Town & Country Planning Act 1990 (as amended)
Town and Country Planning (Development Management Procedure) (England) Order 2015

Application No: BR/82/26/PL
Site Address: 63 Annandale Avenue Bognor Regis PO21 2ET
Description of works: Demolition of the existing dwellinghouse and associated buildings, and the construction of a three-storey building comprising 9 No. self-contained flats with associated landscaping, refuse storage, bicycle storage and parking spaces. This application is in CIL Zone 4 (Zero Rated) as other development.

Thank you for your internet representation made on 16th July 2026 which has been recorded as an objection with the comments as follows:

| DRAWING<br>Proposed<br>Block Plan         |                  |

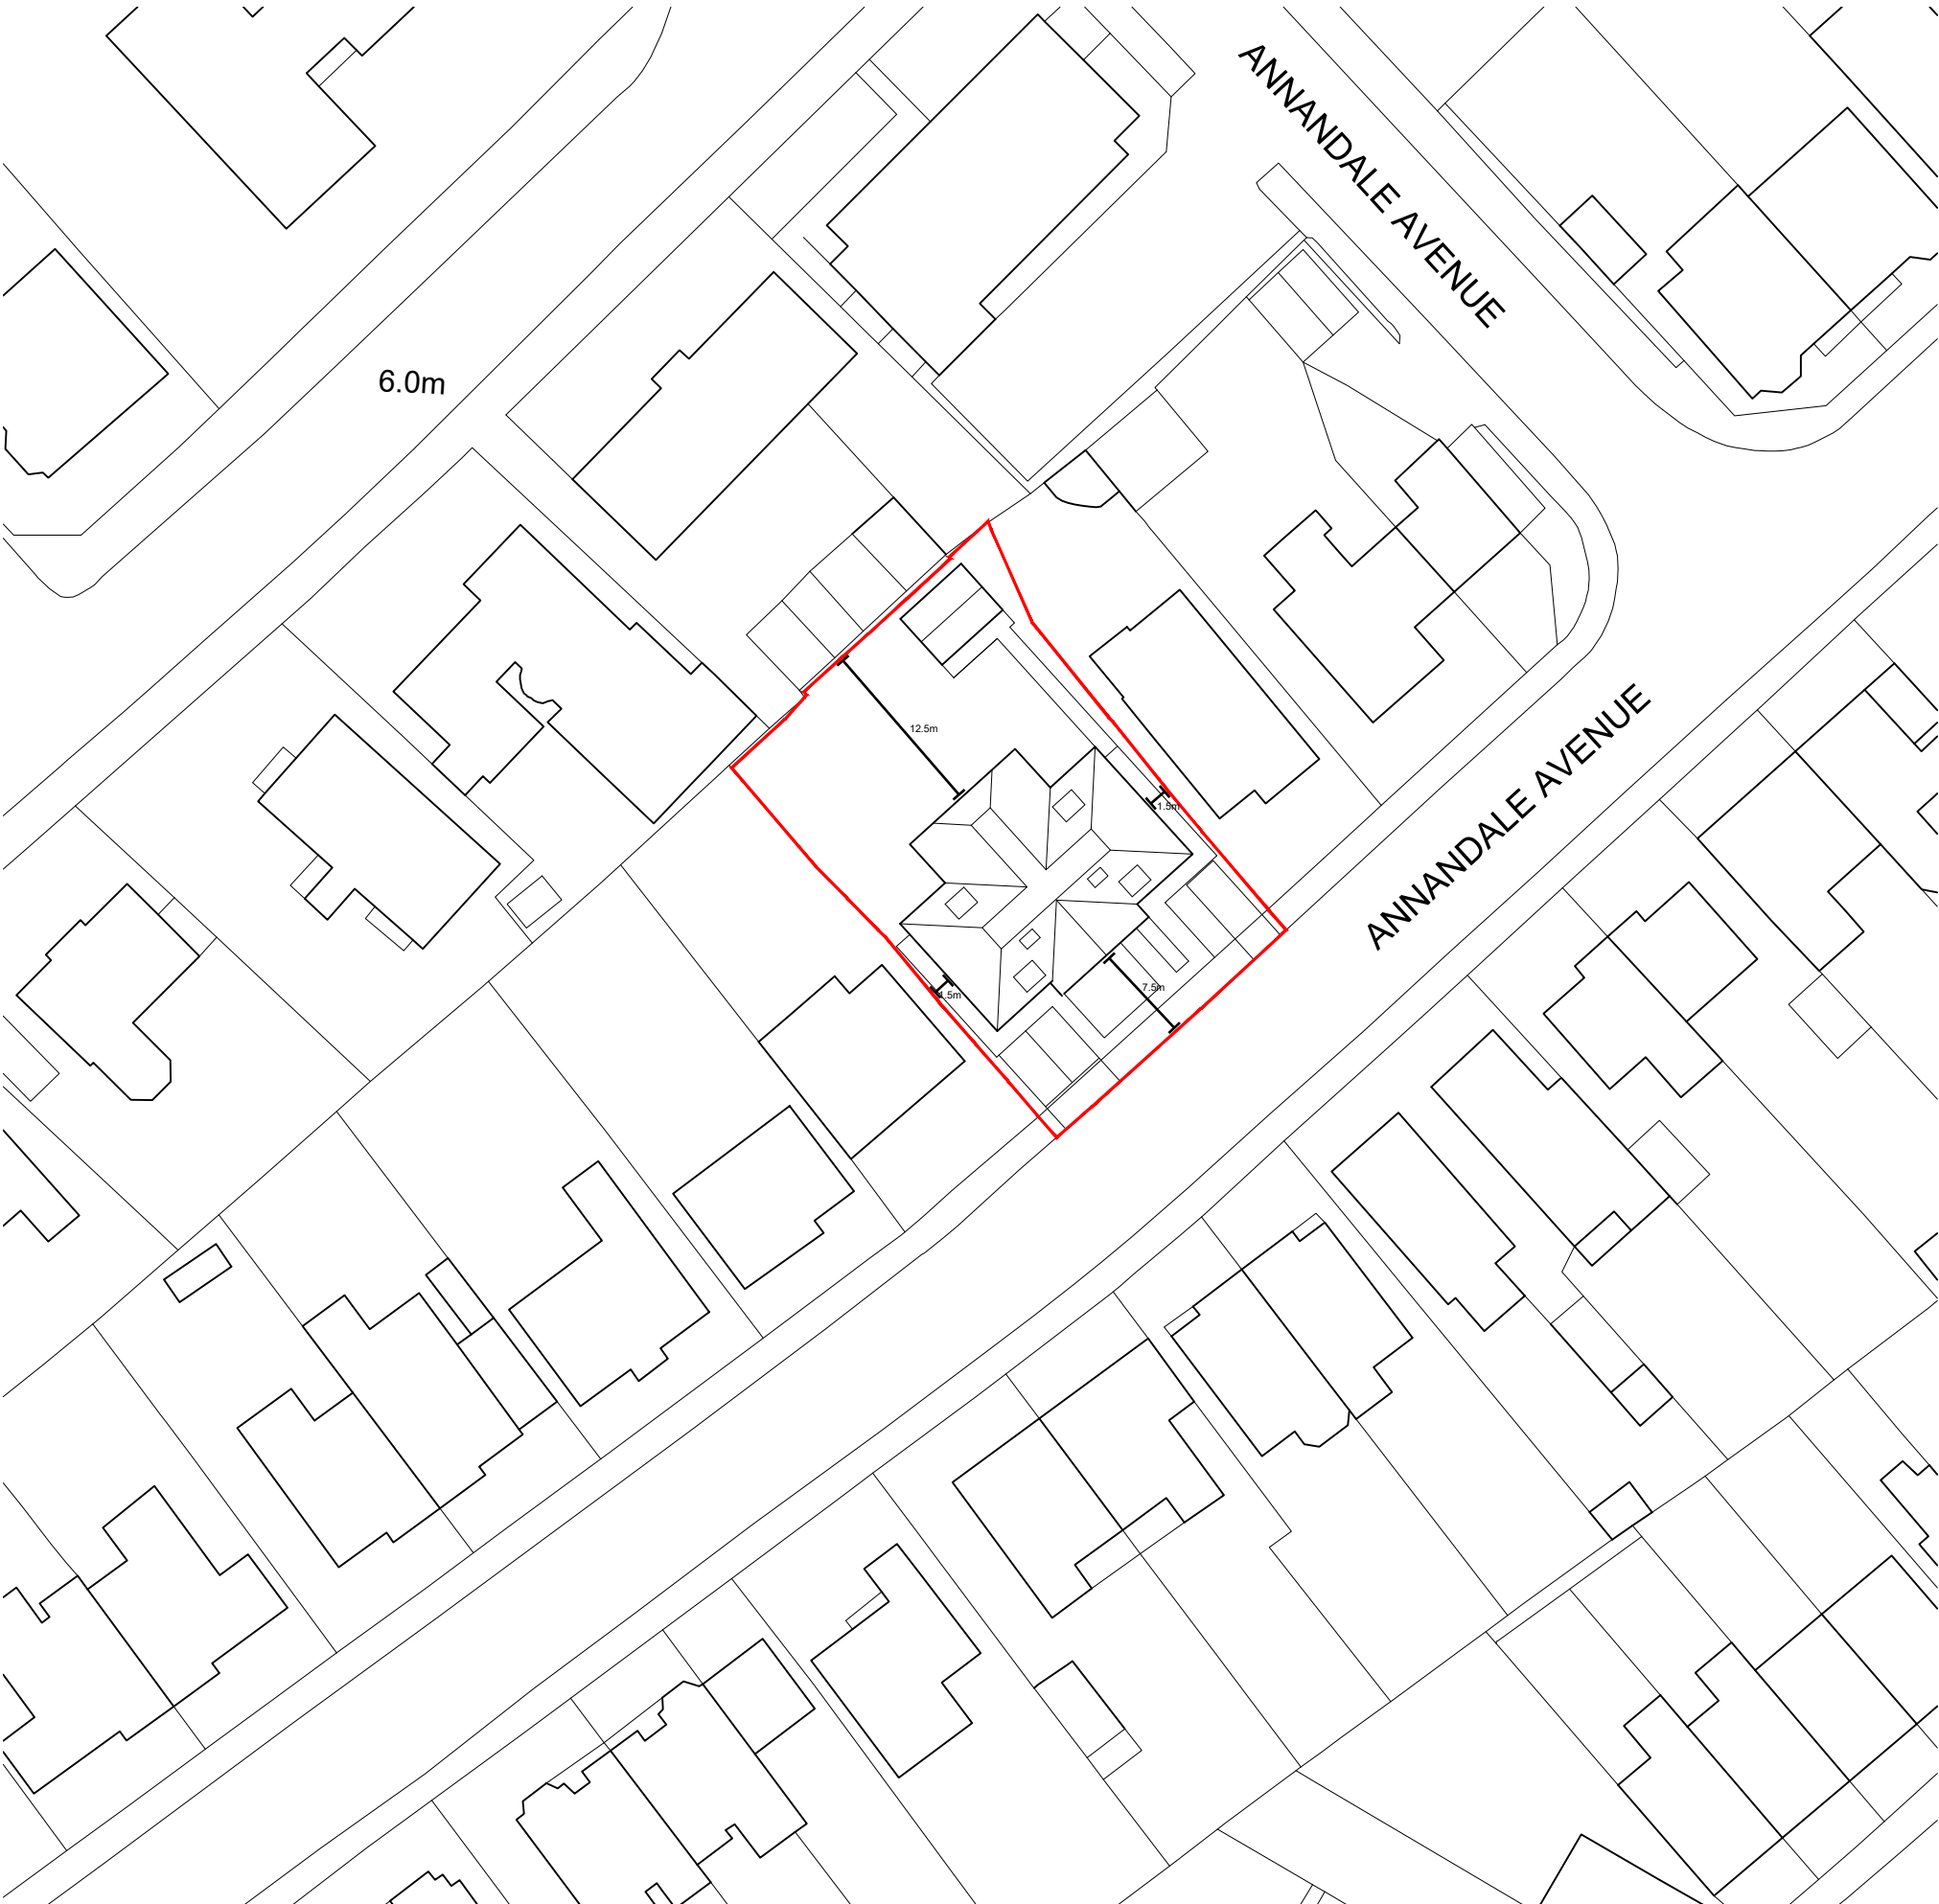
parking availability. There is a veterinary surgery and car mechanic workshops, but also the road is used by single use drivers who park their vehicles before walking to other locations. Additionally, there are only three off-road parking spaces for the nine independent apartments.

DRAWING
Proposed Floor Plans

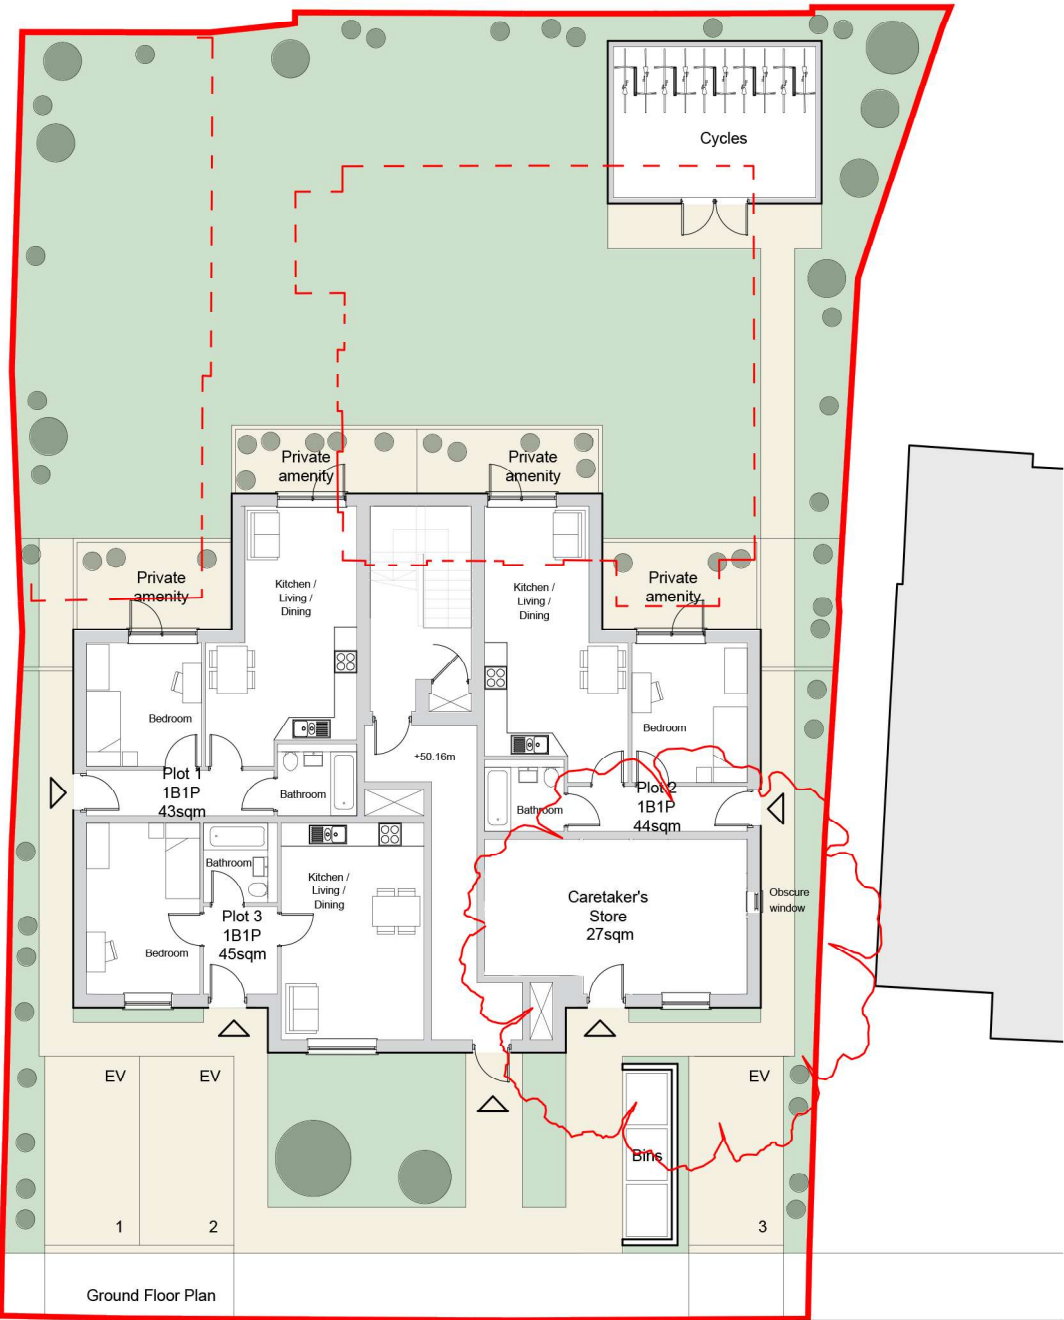
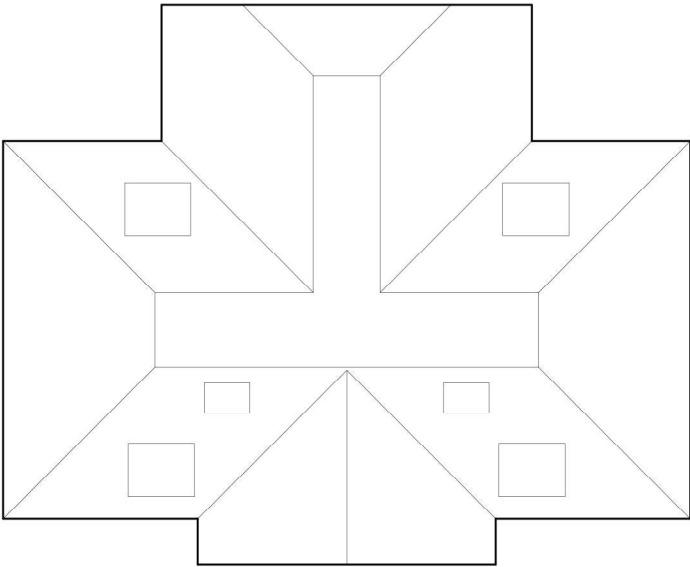
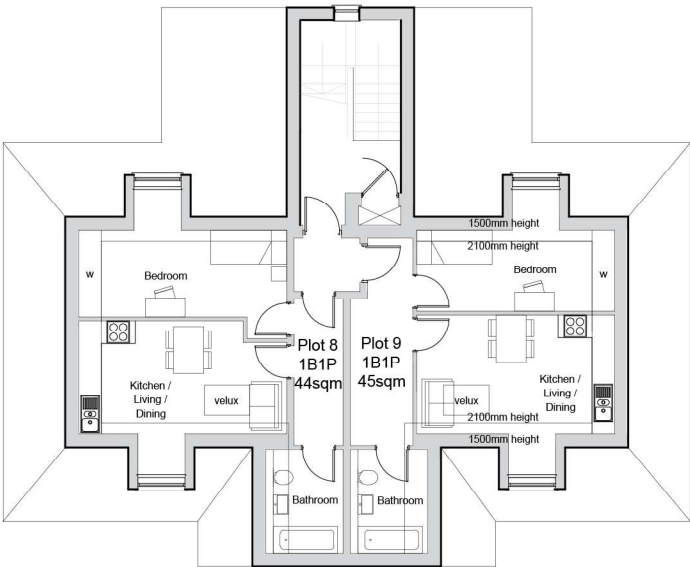
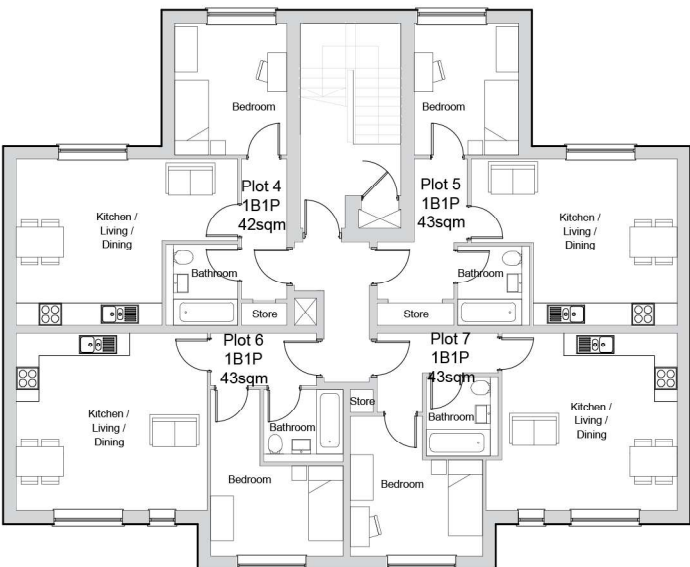
I support comments in general regarding the proposed building structure and feel the actual size is too large, fails to replicate the dwellings or fits in seamlessly with the vicinity as described. There are very few purpose built three storey buildings in the Avenue. Properties that have been converted into apartment dwellings have remained two storeys. Due to this scaling of the building, I also agree with the concerns of the direct neighbours in respect to loss of natural lighting and loss of potential privacy.
